RESPONSE TO SUBMISSIONS (BUILT HERITAGE)

LINDFIELD LEARNING VILLAGE

RESPONSE TO SUBMISSIONS (BUILT HERITAGE) - LINDFIELD LEARNING VILLAGE

Urbis has been engaged to prepare this response to submissions for State Significant Development Application SSD8114, which involves additions and alterations to the former UTS Ku-ring-gai Campus (originally the William Balmain Teachers College). The subject site is located on Eton Road in Lindfield and identified as an item of local heritage significance by Ku-ring-gai Council, item: I422 (Ku-ring-gai Local Environmental Plan 2015).

TITLE
LANDSCAPE MASTERPLAN

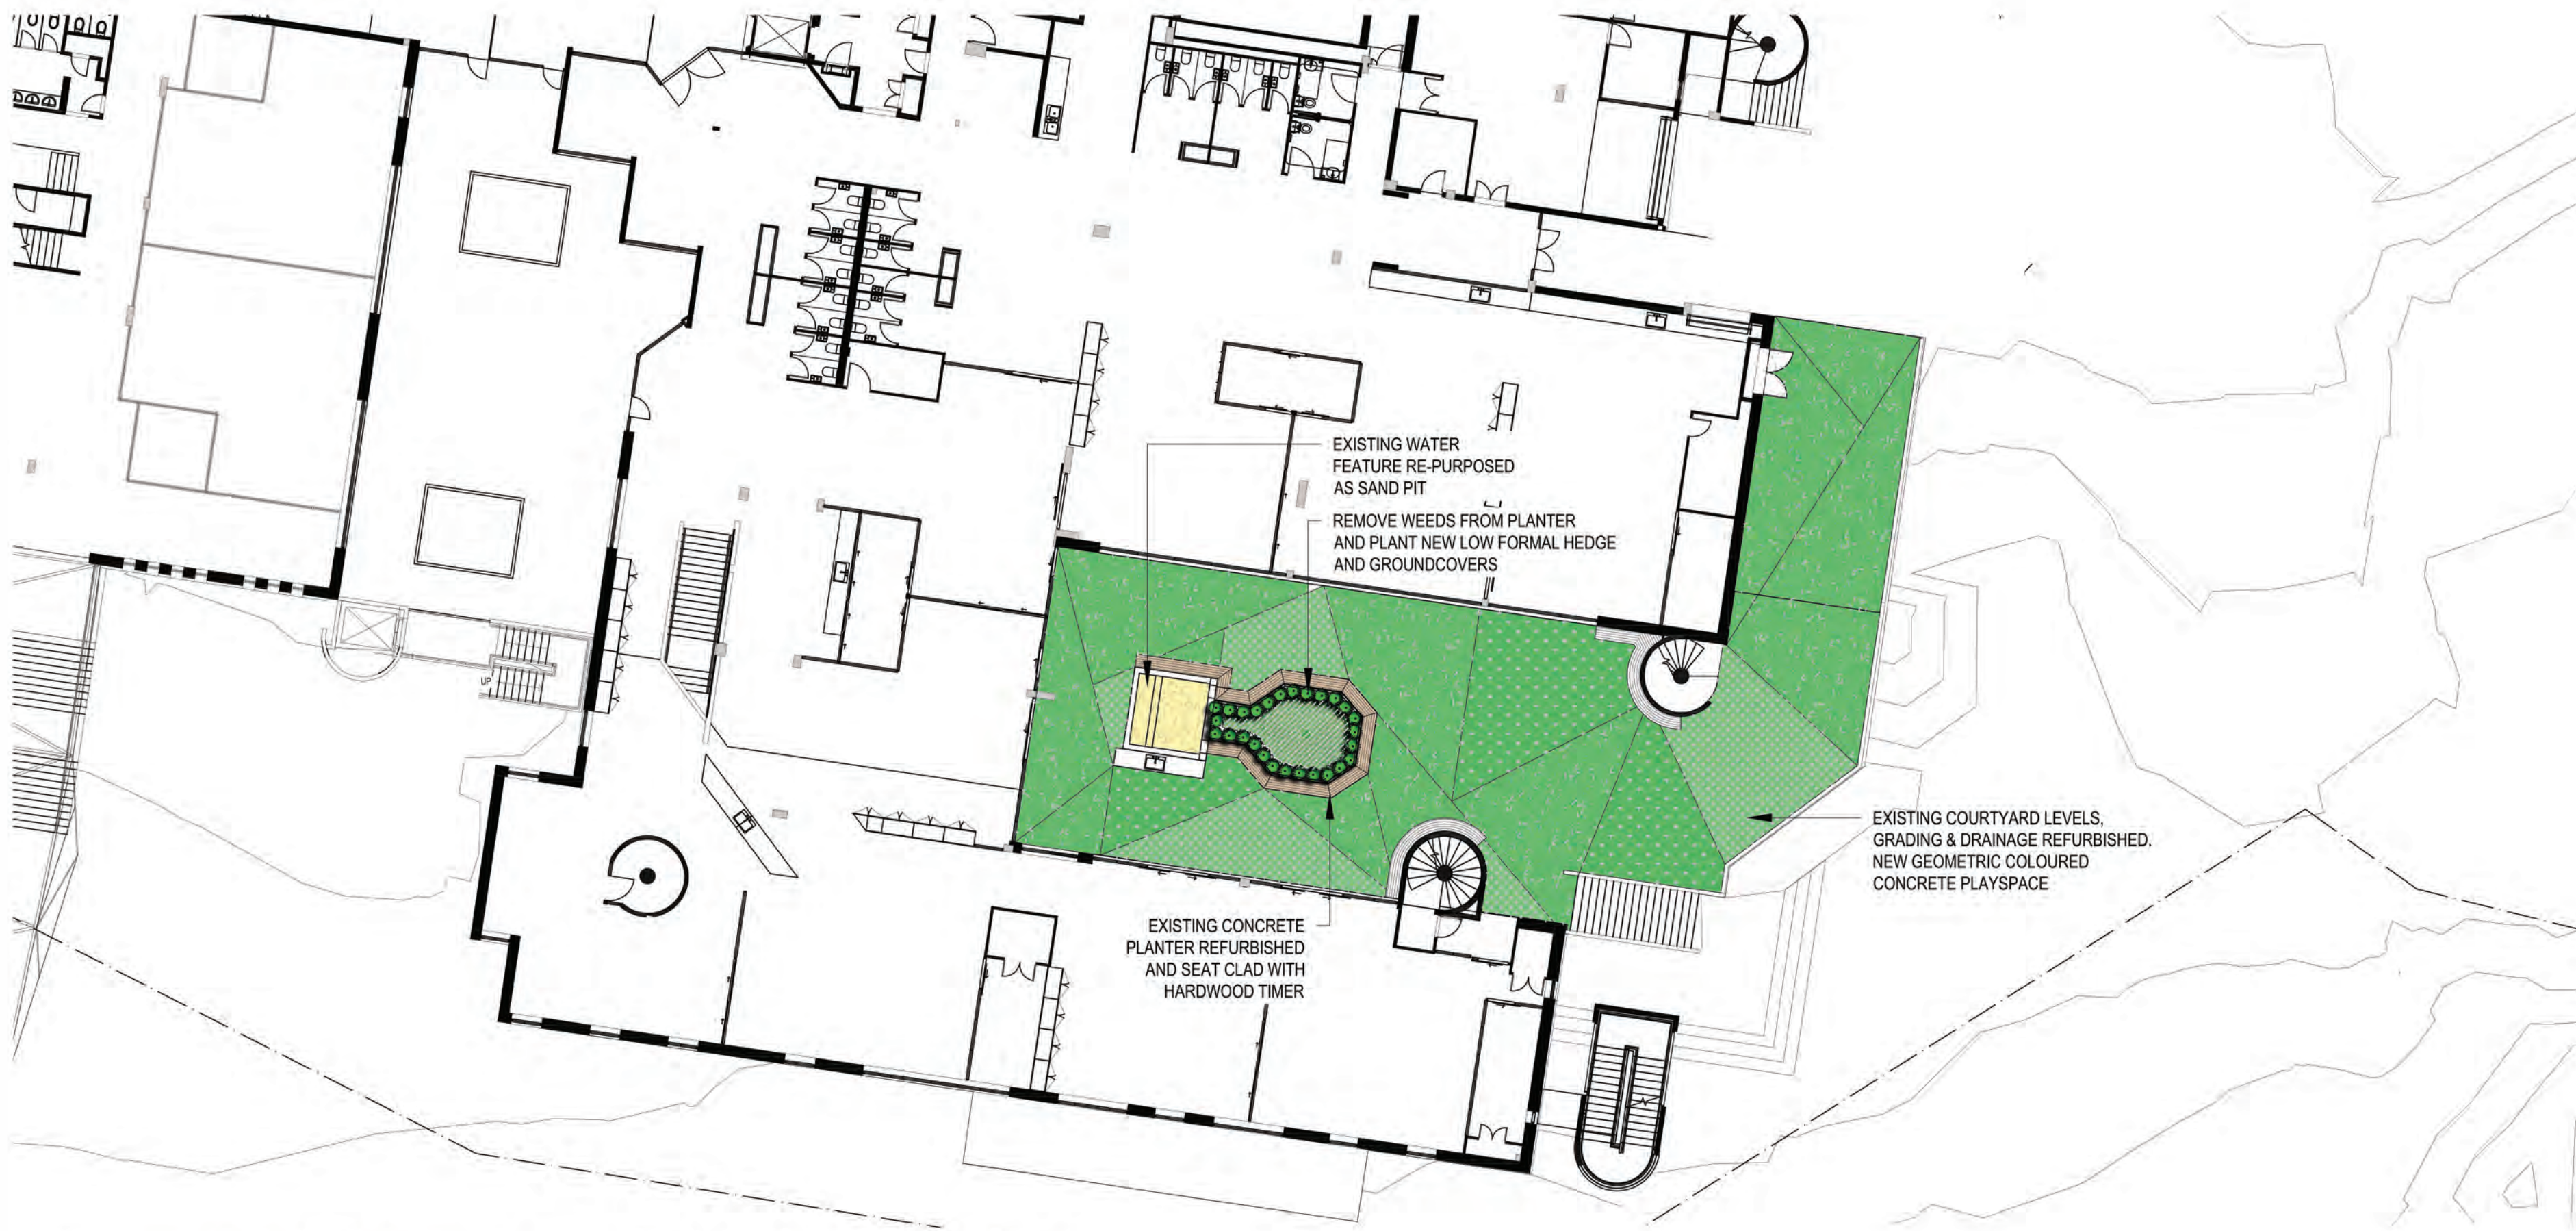
5.11.2 The advice of a landscape architect and the heritage consultant for the project be sought if fire fighting vehicle access routes are required.

The site plan reproduced below indicates a total of 43 trees around the site to be removed. This plan is the result of consultation between the heritage consultant, bushfire engineer, landscape architect and biodiversity consultant. It is understood that this is the minimum number of trees required to be removed to allow for the place to function as a school. The removal of trees would allow for a fire trail, widening of pedestrian paths and the construction of the COLA to the south of the existing building. The bushfire engineer has advised that a 3m buffer around the security fence as previously noted in the EIS is not required and that the fire trail along the southern fenceline is a sufficient buffer.

It is appreciated that areas for tree removal are dispersed around the site. There is no one area where the natural setting would be drastically changed. Further, no removal of trees would occur in the natural bush setting beyond the proposed fencing. As such, the impact on the natural setting is confined to the area in the immediate setting of the building, the density of the vegetation beyond the definable curtilage of the school. Even so, a large number of native trees within the bounds of the school would be retained. The surveyed trees and number identified for removal (as shown on the drawings) indicates that for the 43 trees that are to be removed there are 595 within the site which will

EAST & WEST BUILDING ELEVATION

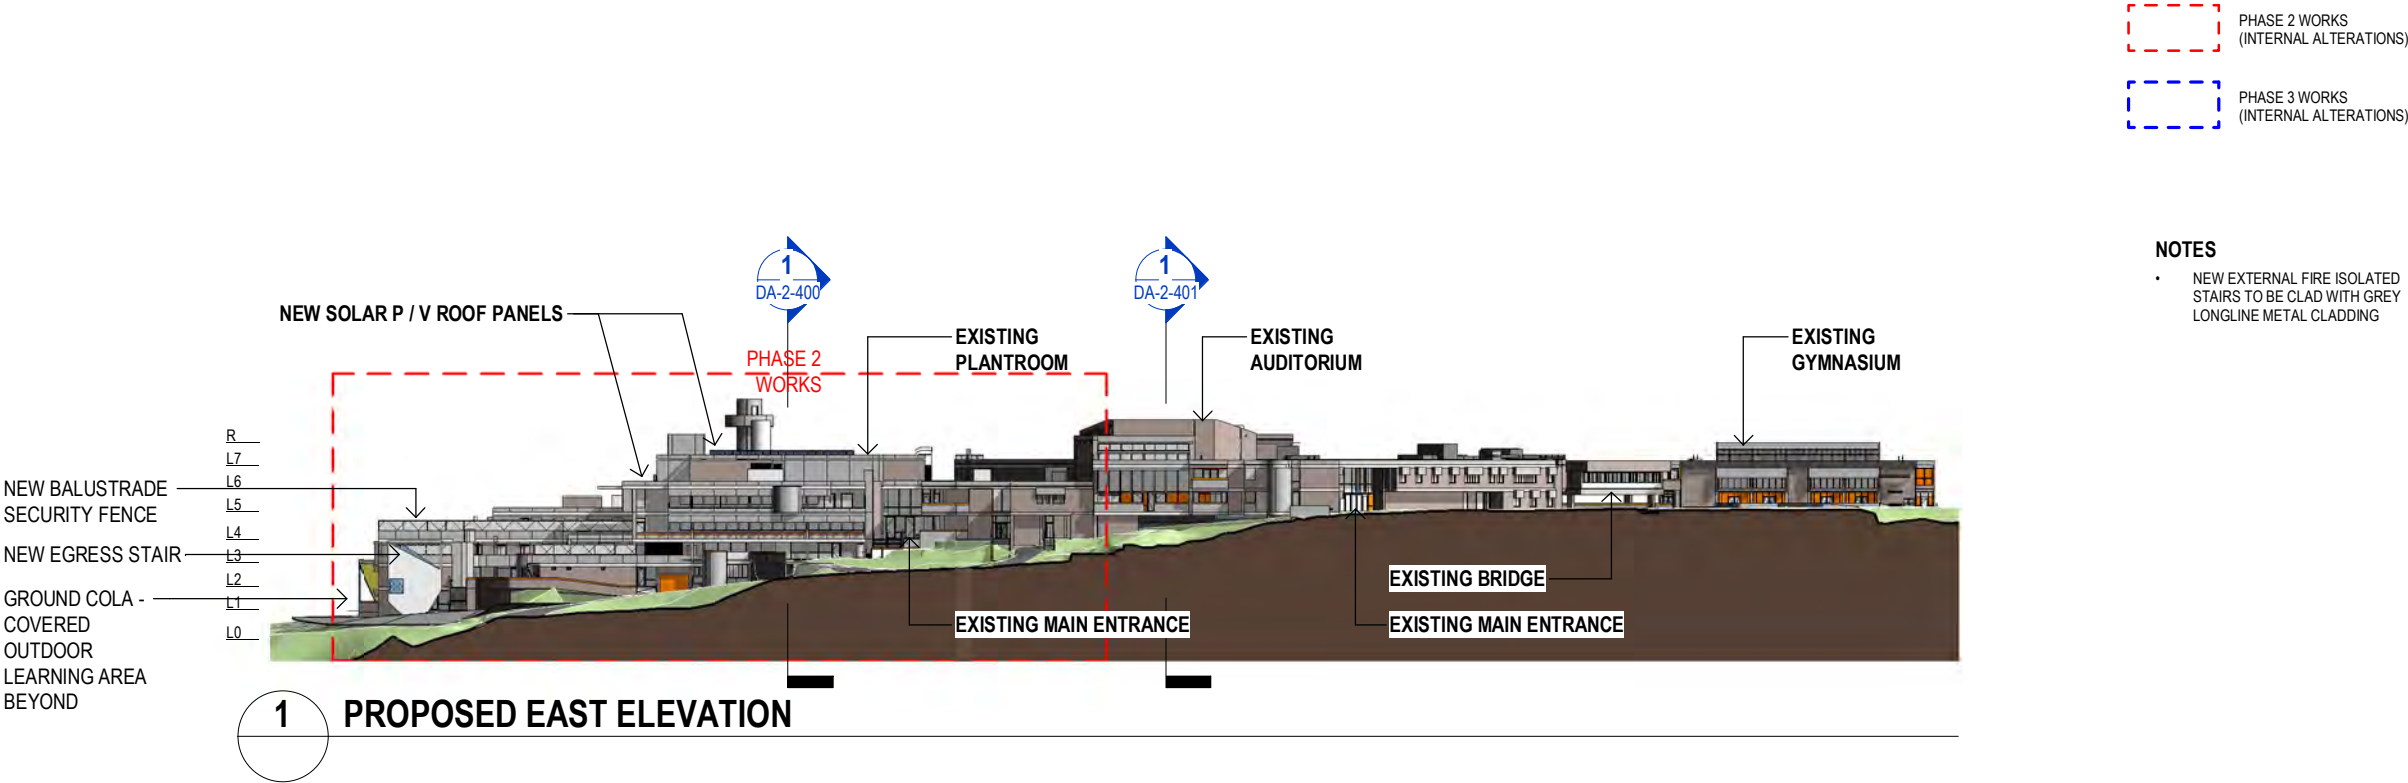
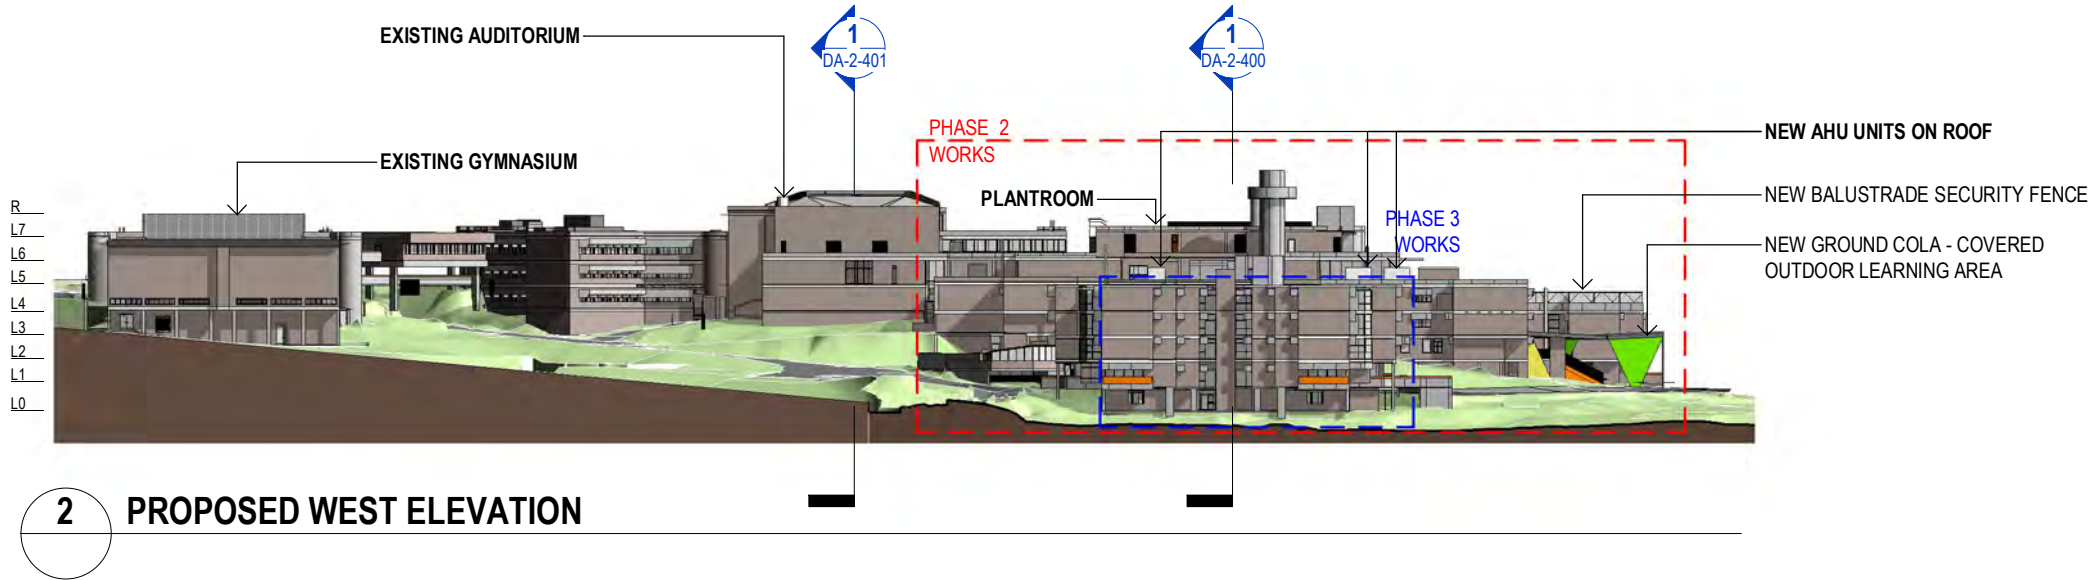
5.11.3 The colour scheme of the proposed new built and landscape elements should be changed so that the external colours are muted colours reflecting the colours of existing adjacent built and landscape elements.

Where there are new additions to the Stages 1 and 2 significant building forms, the outward planes are proposed to be silver/grey zincalume as shown in the images below. The coloured panels would be concentrated to the inside faces of the additions.

The images below indicate the revisions to the scheme in terms of the application of coloured cladding to the new elements. This is in accordance with Council’s recommendations and ensures there is a stronger tonal relationship between the new and old elements. The coloured cladding is now minimised in the most significant areas (being building Stages 1 and 2).
